REQUEST

Current Zoning: I-1 (Industrial)
Proposed Zoning: MUDD-O (Mixed-Use Development District-Optional)

Approximately 0.48 acres located north of Freedom Drive, south of Thrift Road, and east of Berryhill Road.

The petition proposes to rezone the site to MUDD-O to adaptively reuse the site for residential and non-residential uses.

EXISTING/PROPOSED FREEDOM DRIVE CROSS-SECTION

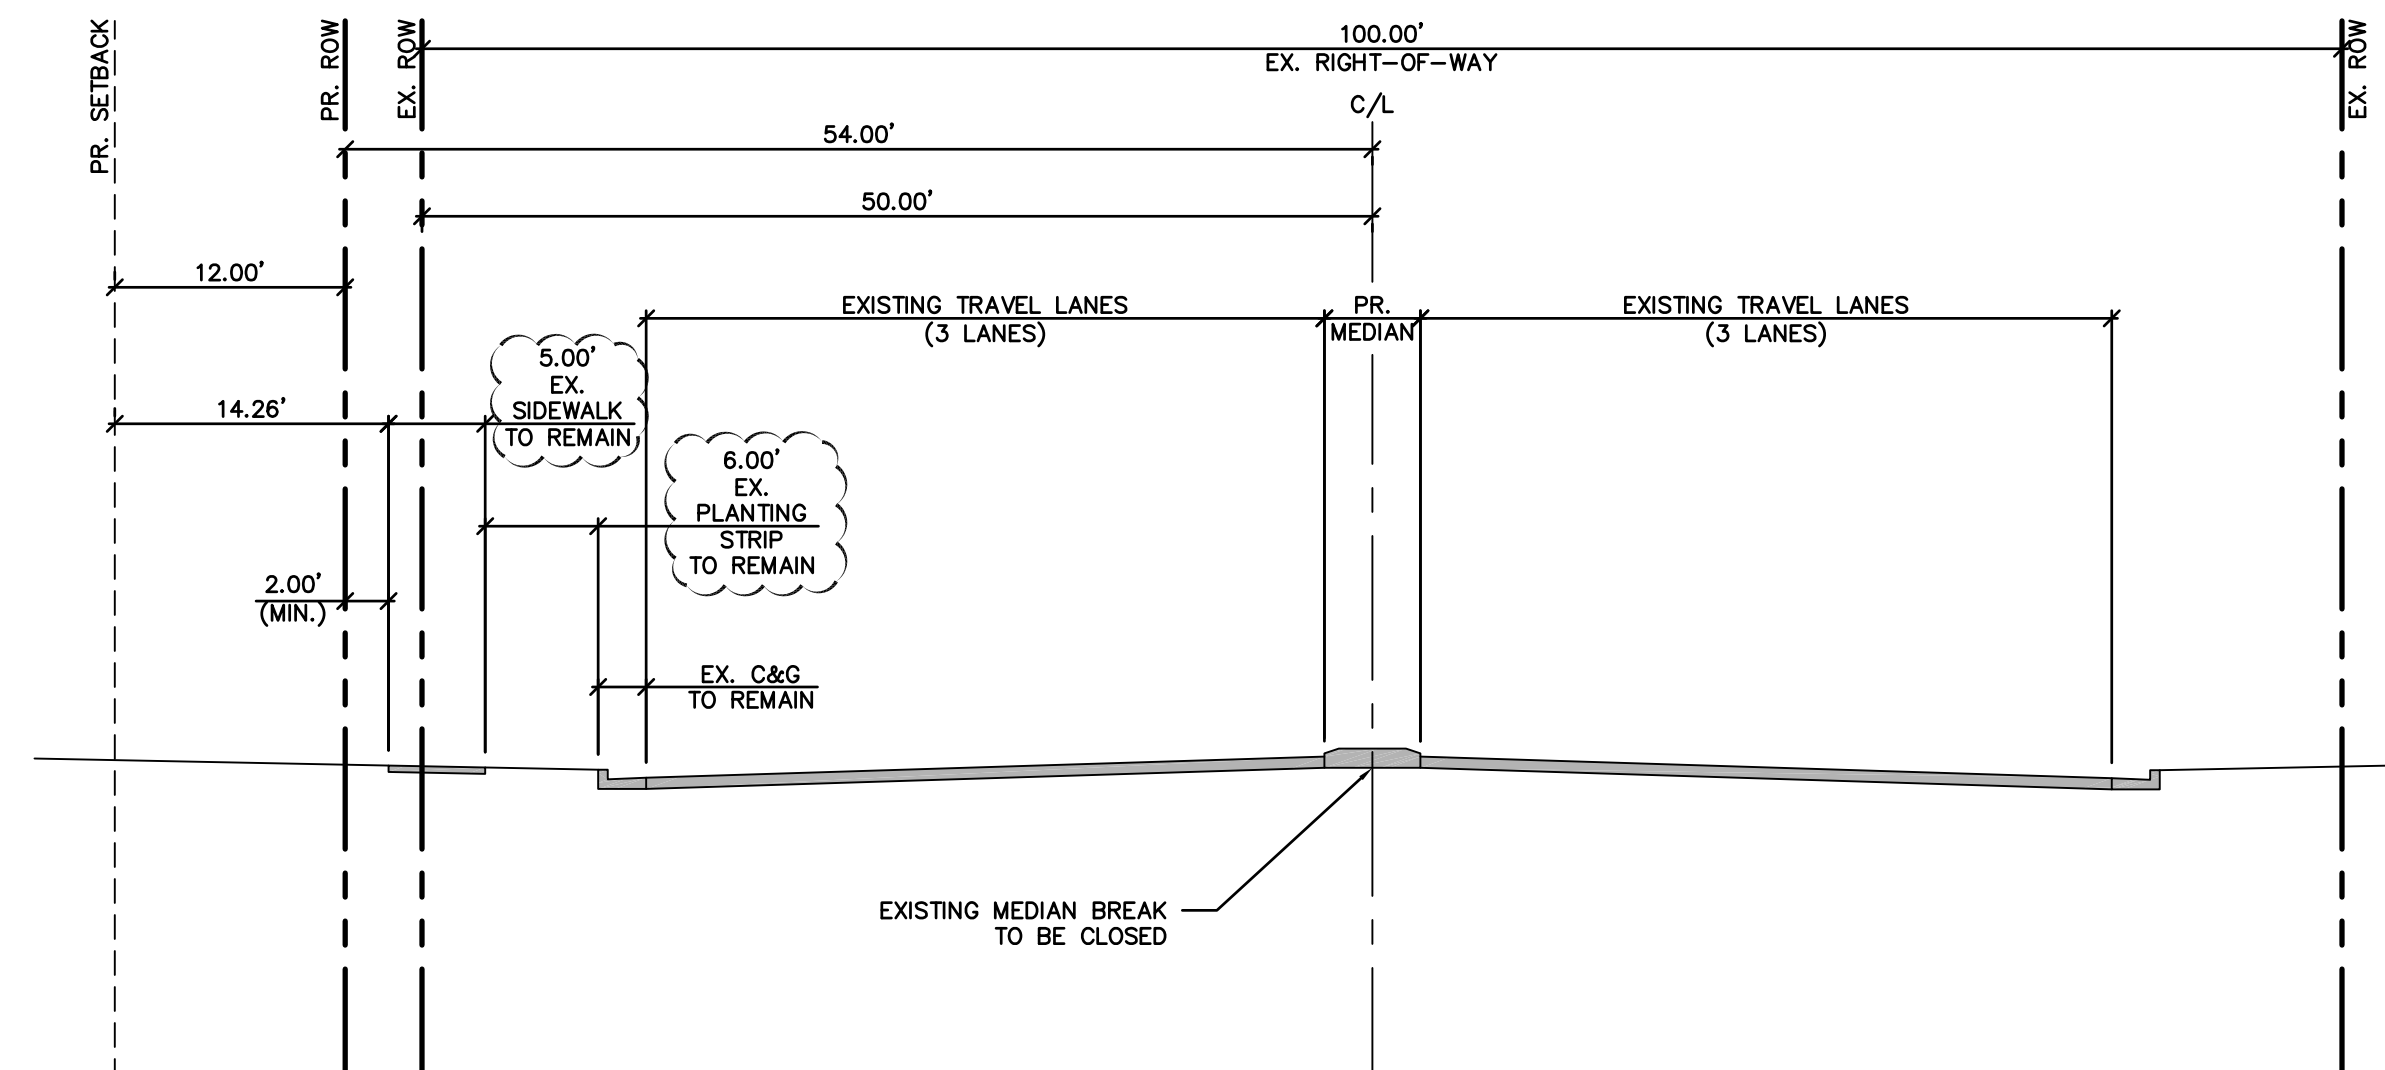
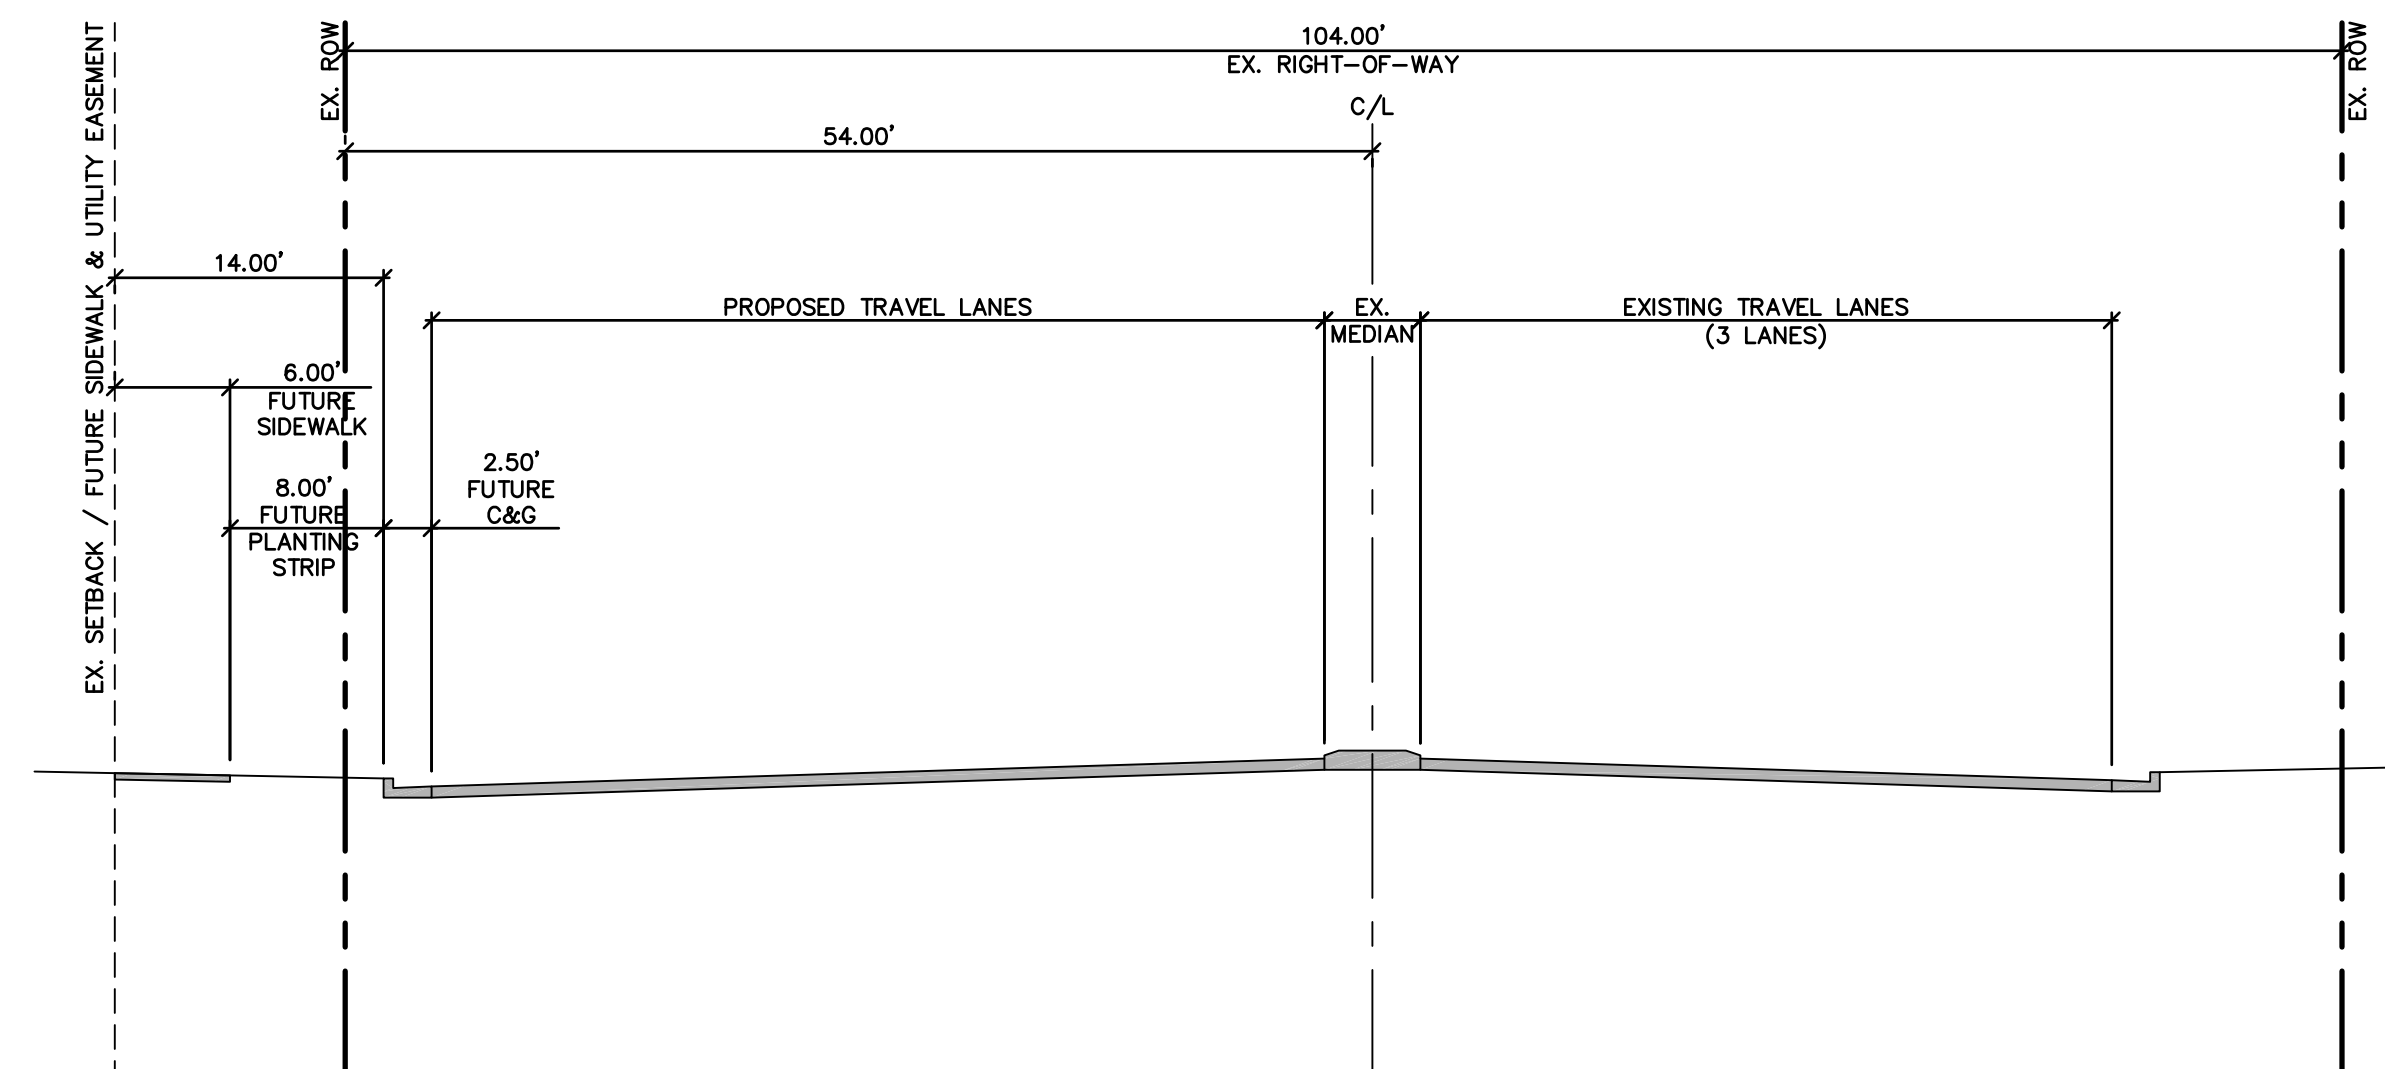
2. On the development table, specify that the number of residential units and non-residential is the maximum.
3. Add to note 2b that developer will work with CDOT and Urban Forestry staff during permitting on modifications to street scape.
4. Provide dimensions for existing sidewalk and planting strip on cross section and in notes.

1. The petitioner should revise the site plan right-of-way dedication and to add a note specifying dedication of additional right-of-way of sidewalk utility easement to accommodate a future 12-ft multi-use path, in accordance with Charlotte BIKES.
